Re: **Bradley Heights PUD Development Plan** – Third Review Comments **File # AR PUD 21-00206**

We are in receipt of your review letter dated November 24, 2021. Below is a point by point response to these comments prepared in coordination with the Developer (Challenger Homes) and the Design Team (HRG). New comments are indicated by **purple font**.

### PUD Development Plan

TYPICAL LOTS

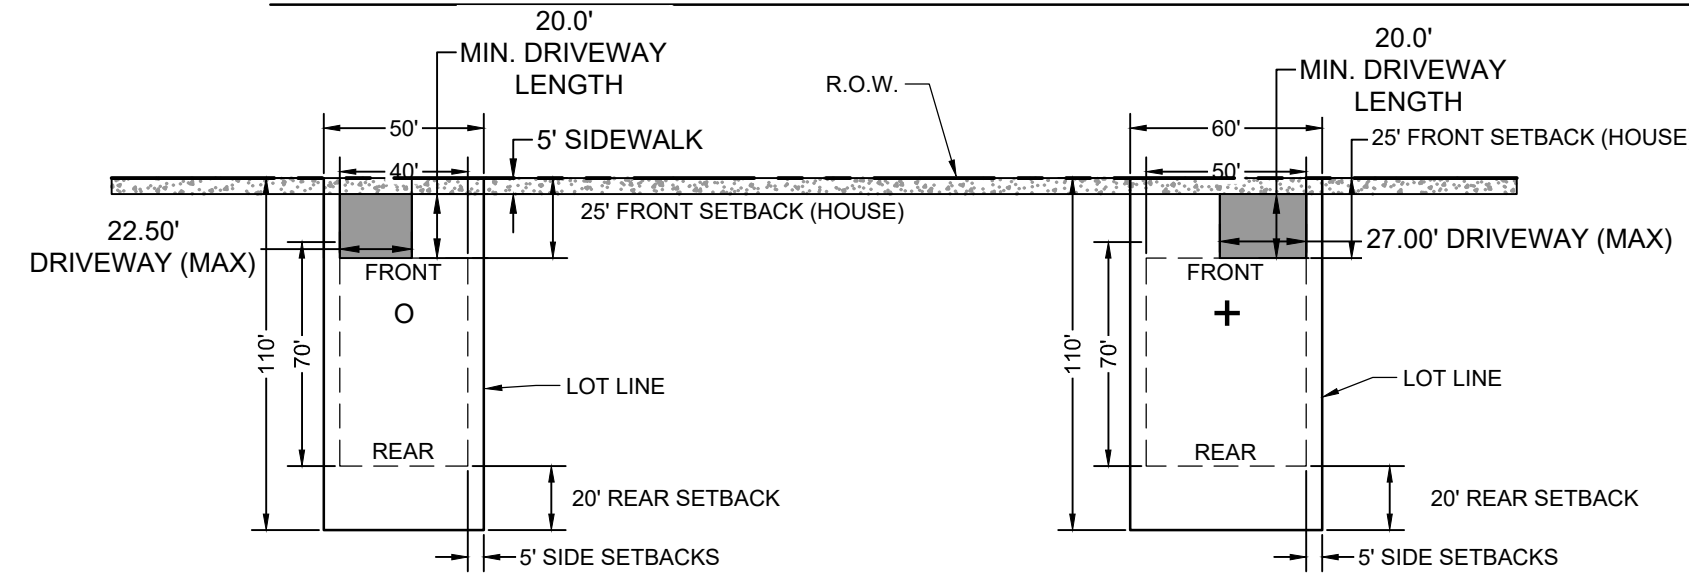
1. Please add a table on the cover sheet to demonstrate parking spaces provided, and whether the spaces are in the private garages, in driveways, or on-street. Also call out the driveway width for lot typicals (50-foot-wide vs. 60-foot-wide lots) and whether one-car or two-car garages are to be provided with the homes.

Partially addressed. Small-lot PUD guidelines do have standards for guest parking. Since many of the lots in this proposed development meet the 6,000 square-foot lot size or less, these guidelines apply to those units. Please indicate in a table and/or other graphic illustration where the guest parking spaces will be located, and how many spaces are provided compared to how many of the lots are less than 6,000 square feet.

**RESPONSE (HRG): The following note 19 has been added to the cover sheet: 19. TYPICAL HOMES WILL HAVE TWO-CAR GARAGES WITH DRIVEWAY WIDTHS AND LENGTHS SUFFICIENT FOR THE PARKING OF TWO VEHICLES. The driveway lengths and widths have been called out on the lot typicals. It is our understanding that there is no specific parking requirement for typical single family lots thus a parking table has not been added. Sufficient areas for parking are provided in garages, driveways and on streets (where there is no restrictions for emergency access).**

**RESPONSE (HRG): The average lot size for this project is 7,479 sq.ft. and per our coordination via email this development does not require guest parking.**

**CUSTOM COLLECTOR -
BRADLEY LANDING BLVD.**
NOT TO SCALE

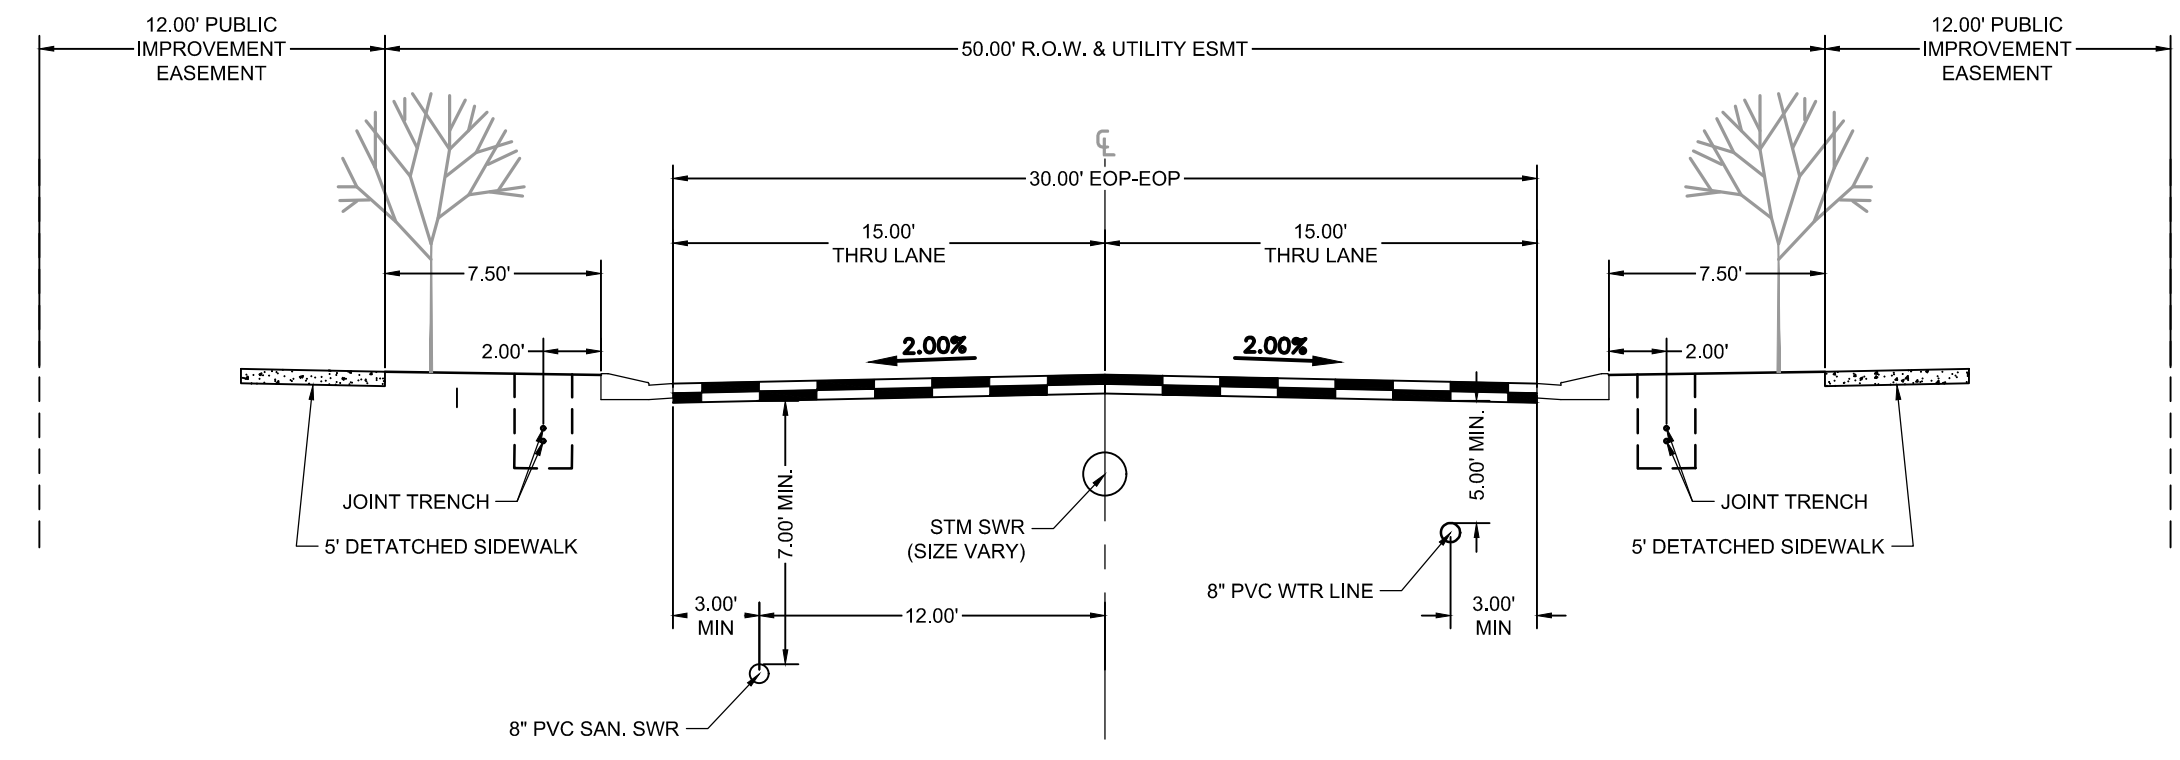
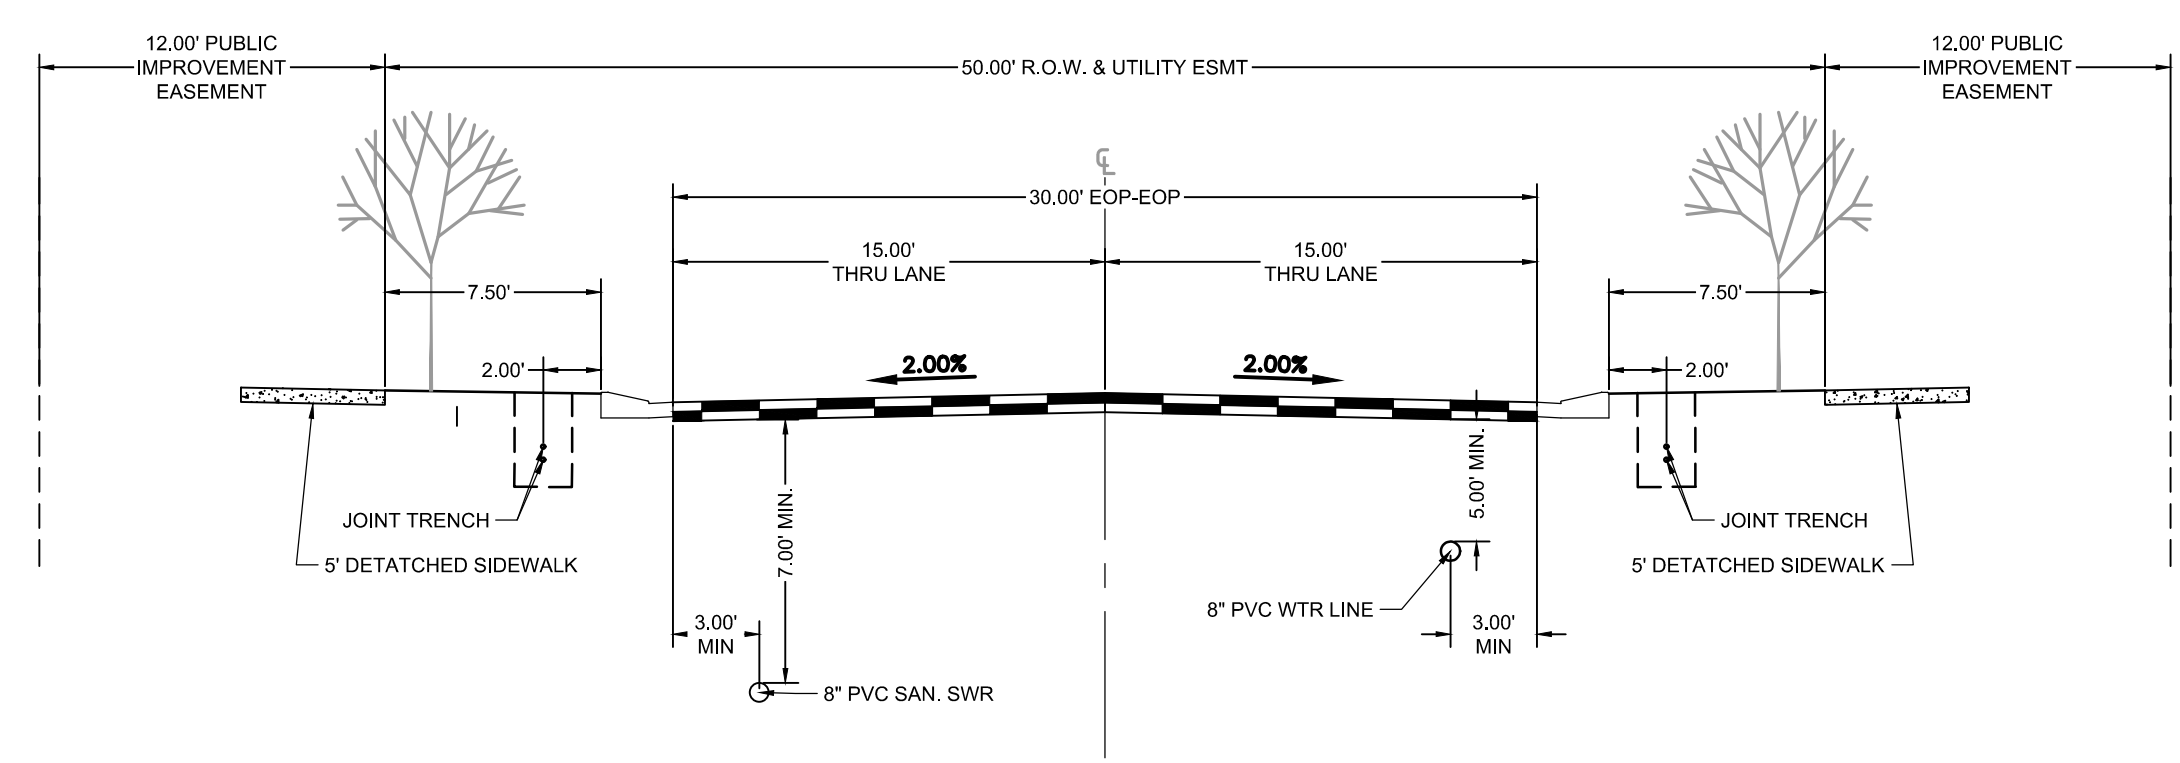
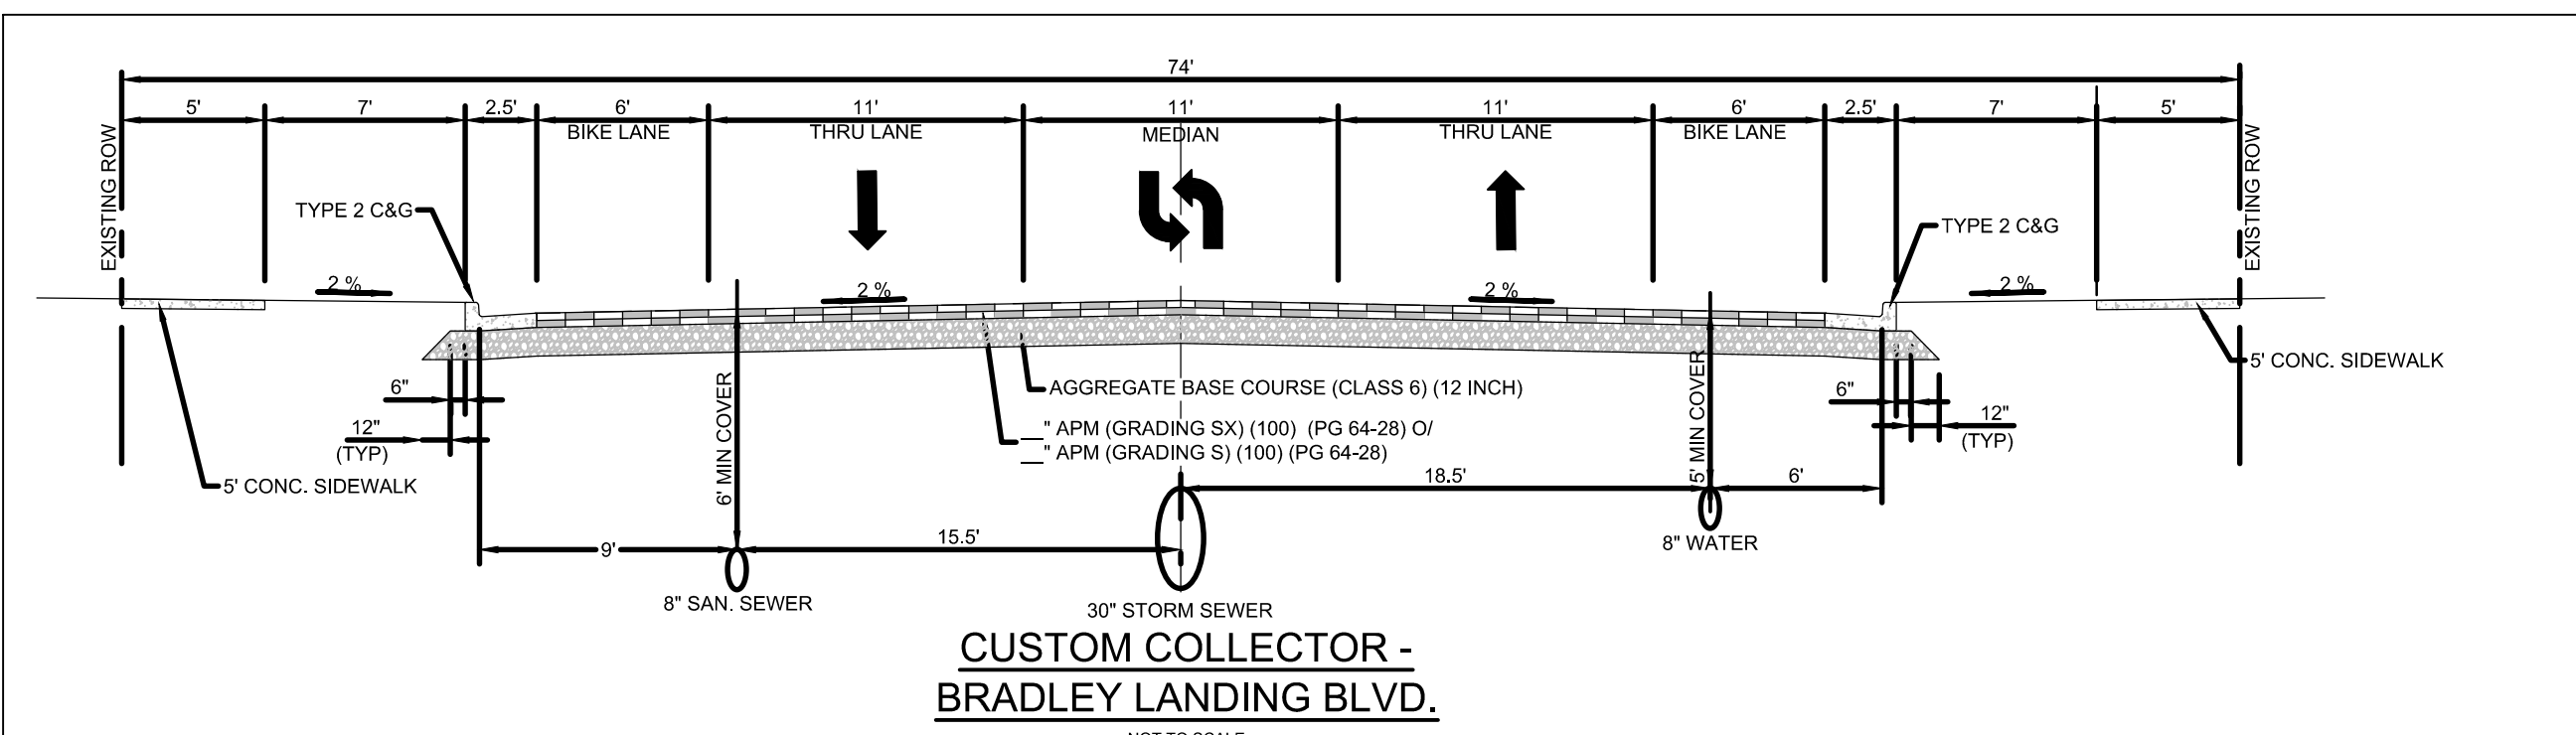
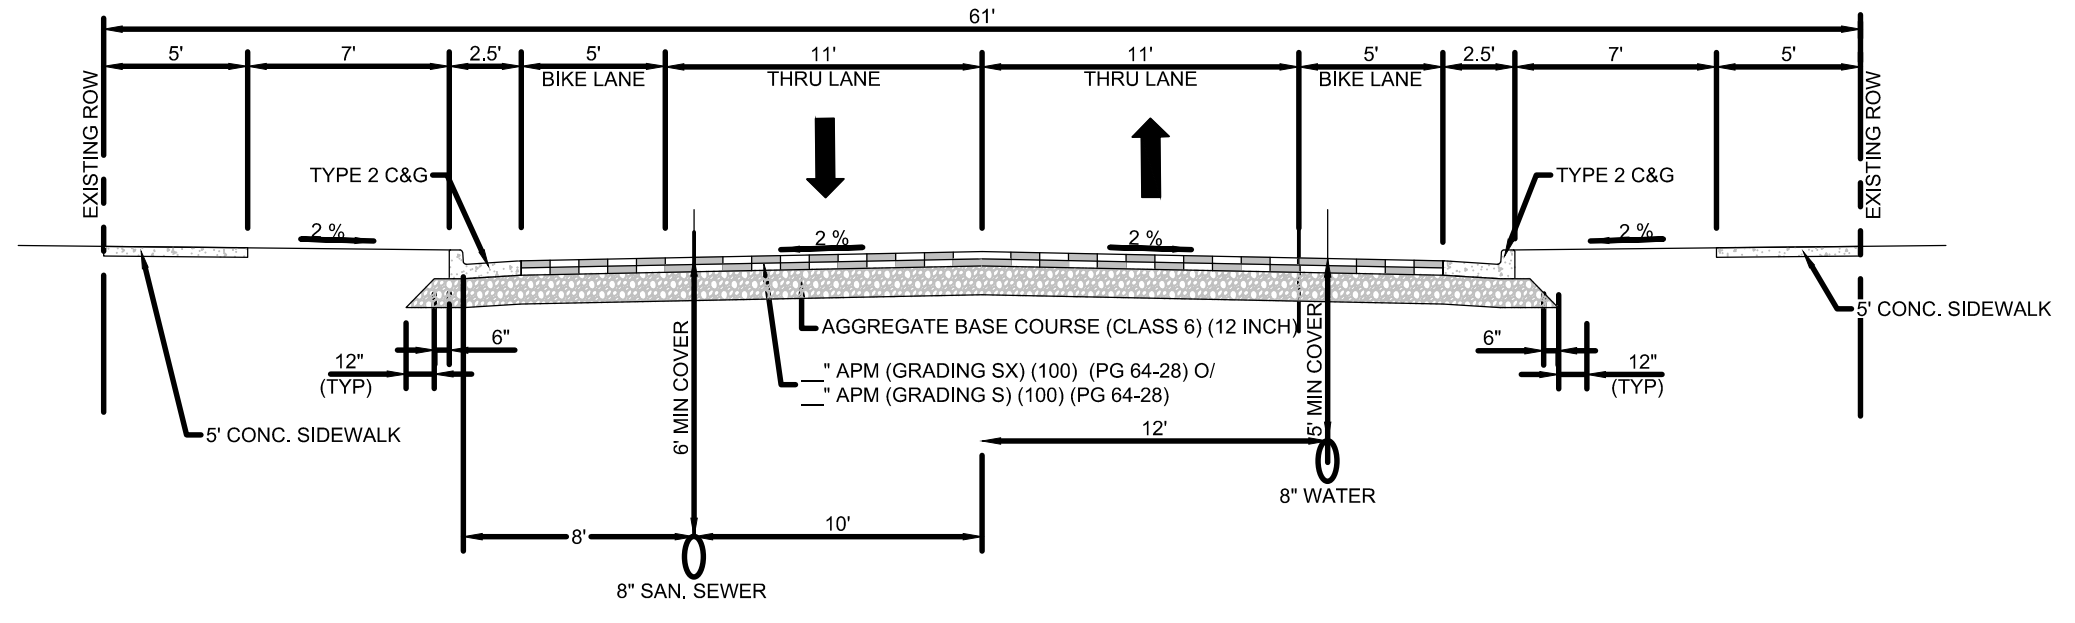
18. The proposed future CSU water main within Bradley Landing is way too close to the curb and gutter. All cross sections are required to show on the plan, and they need to be the current cross sections with CSU standards.

**RESPONSE (HRG): Addressed, we have included the see cross sections on sheet 3 which were provided by Matrix Design Group which has been designing Bradley Landing Blvd. and associated utilities.**
